CITY OF ALBUQUERQUE

April 7, 2021

RE: 3821 12th Street NW
Grading and Drainage Plan
Engineer's Stamp Date: 11/24/20
Hydrology File: G14D096

Based upon the information provided in your submittal received 04/06/2021, the Grading & Drainage Plan **is not** approved for Building Permit. The following comments need to be addressed for approval of the above referenced project:

GRADING &  
DRAINAGE  
PLAN

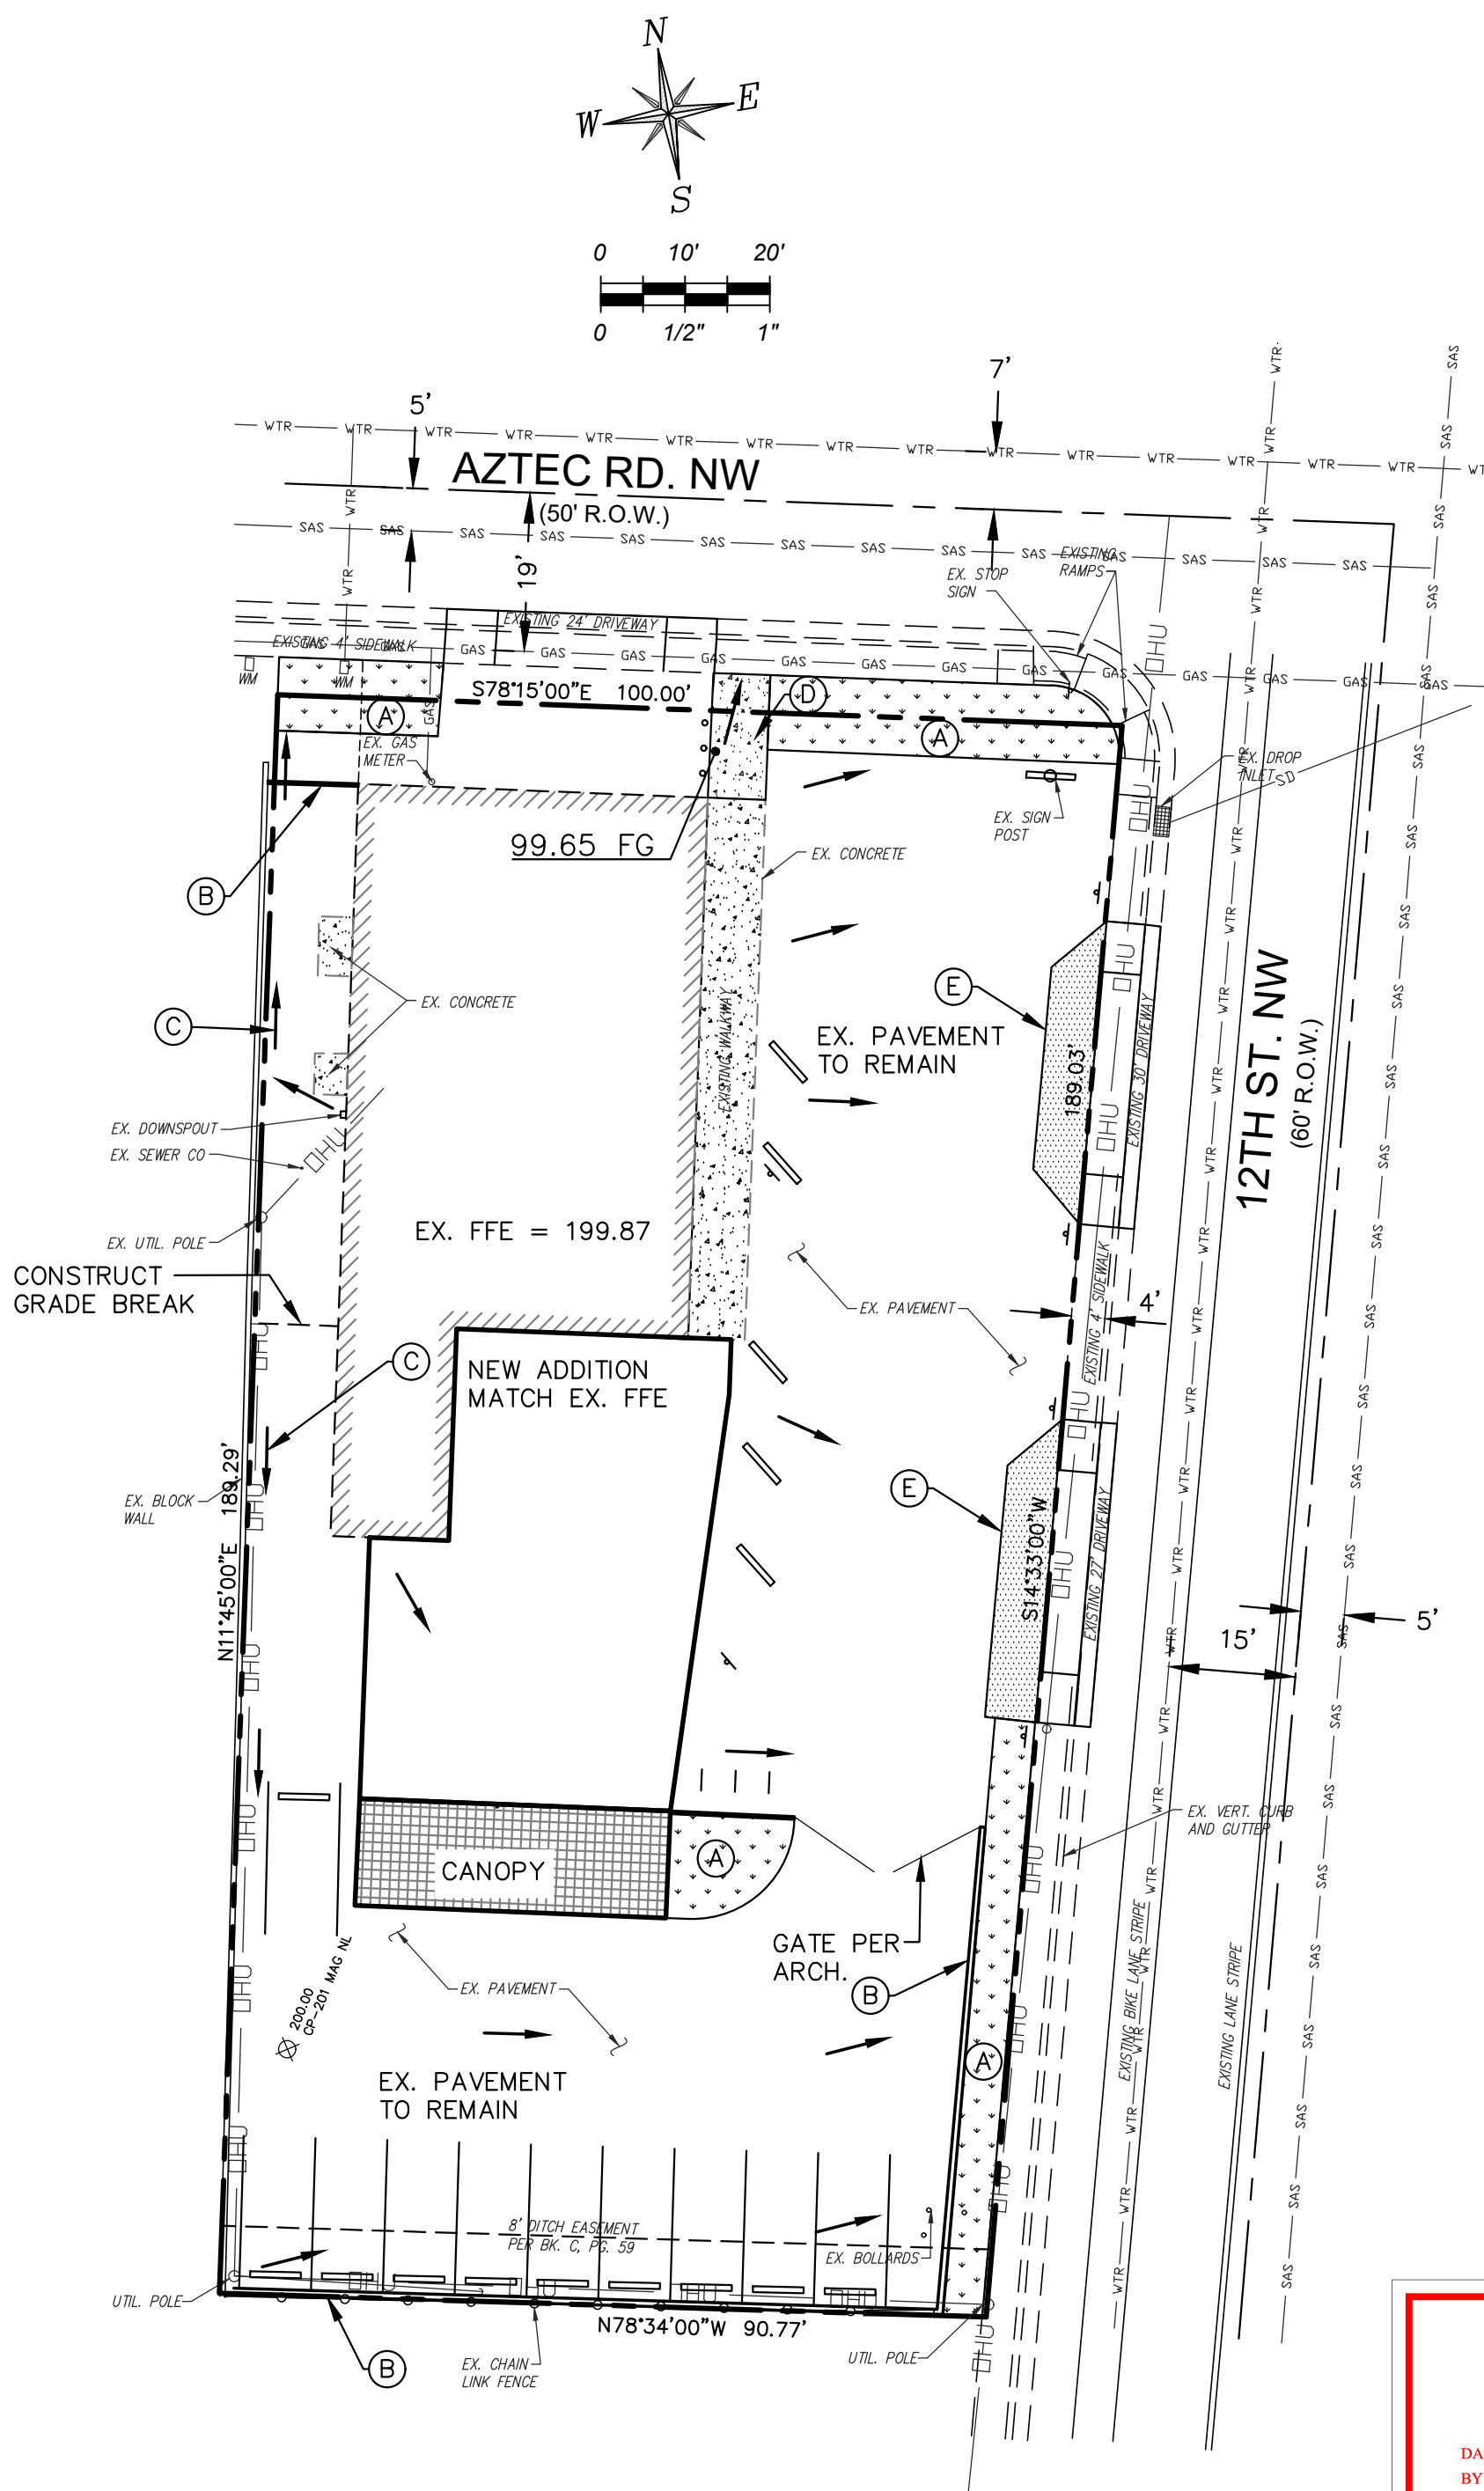
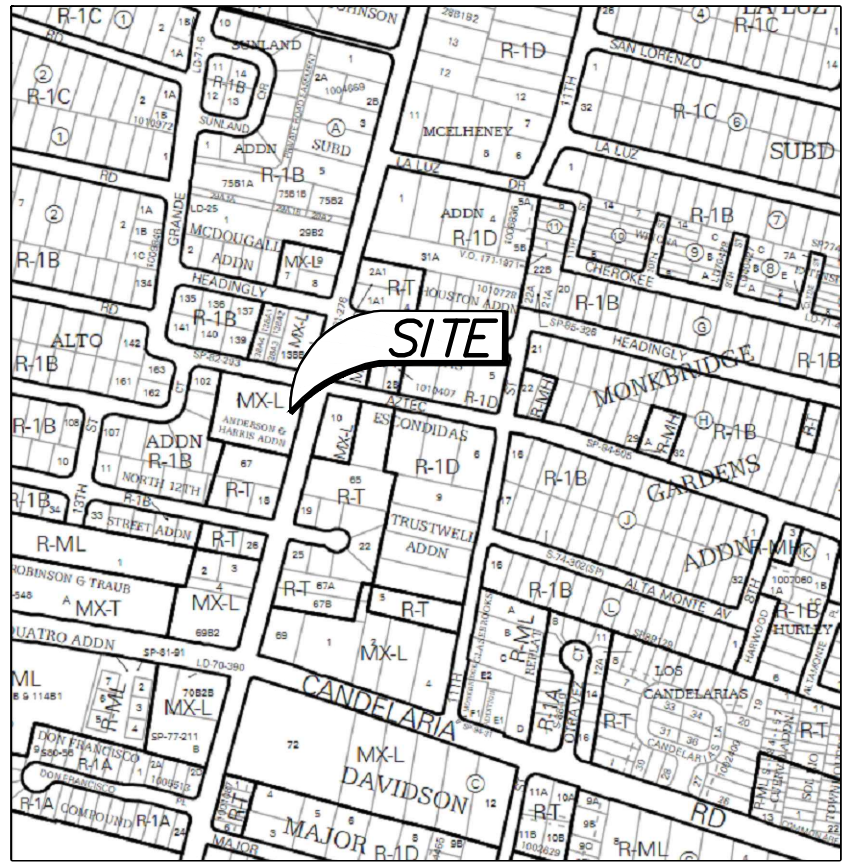
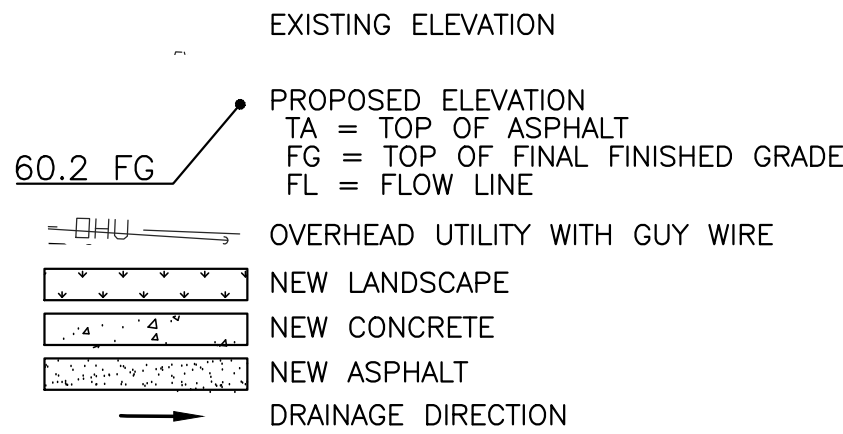
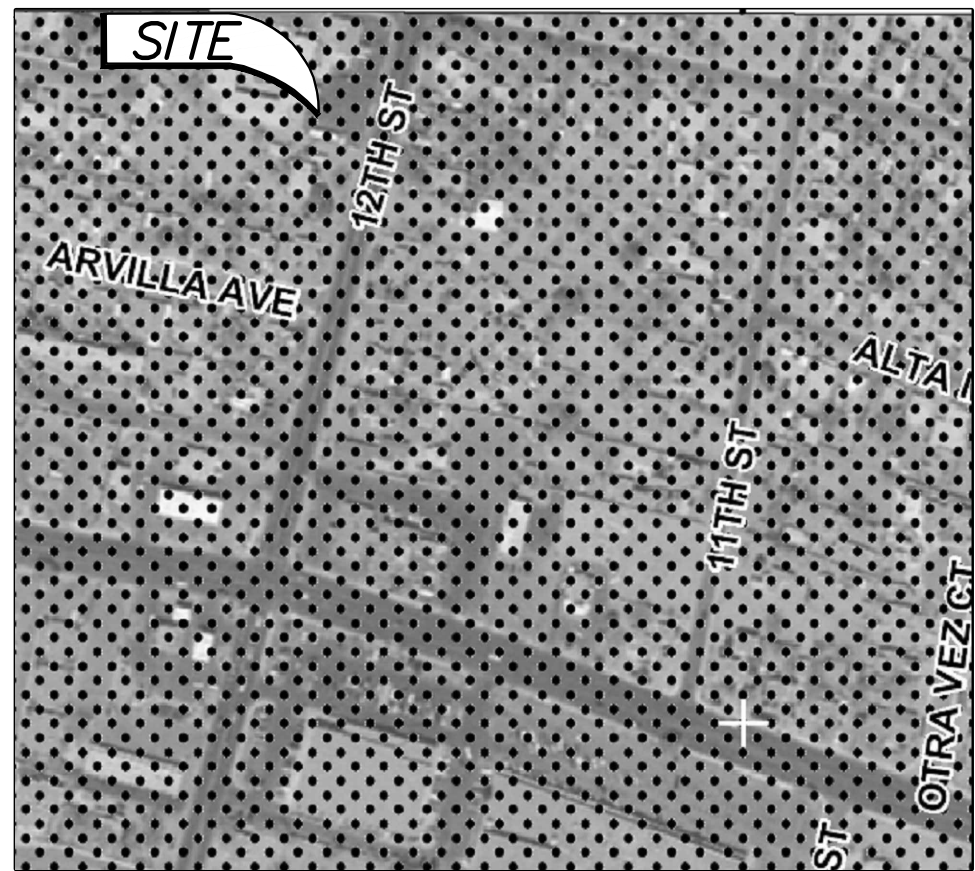
1. Please use the procedure for 40 acre and smaller basins as outlined in Development Process Manual (DPM) (signed 06/08/20) Article 6-2(a). Please provide both the existing conditions and proposed conditions for the 100-year 6-hour storm event.

2. Provide management onsite for the Stormwater Quality Volume (SWQV) in accordance with the new drainage ordinance, § 14-5-2-6 (H) enacted 10/2/18 (Council Bill C/S O-18-2) and as outlined in DPM (signed 06/08/20) Article 6-12 Stormwater Quality and Low-Impact Development for the sizing calculations. Since this site is a redevelopment the SWQ pond volume will be $0.26 * \text{new impervious area (new paving, sidewalks, and building) (sf)} * 1/12$. If you are planning to provide for the SWQ volume, please show the top and bottom of the ponds along with the volume for each pond within the landscape areas. The onsite drainage should be directed to these ponds via curb cuts prior to either being collected in the existing inlet or leaving the site for the public drainage system. If you are going to not provide for the SWQ volume within the landscape areas, then you will need to add a statement, "The Owner has elected to pay for the Stormwater Quality Volume. The Payment-in-lieu will be $\$8 / \text{CF} * \text{SWQ volume (CF)} = \$ \text{XX}$."
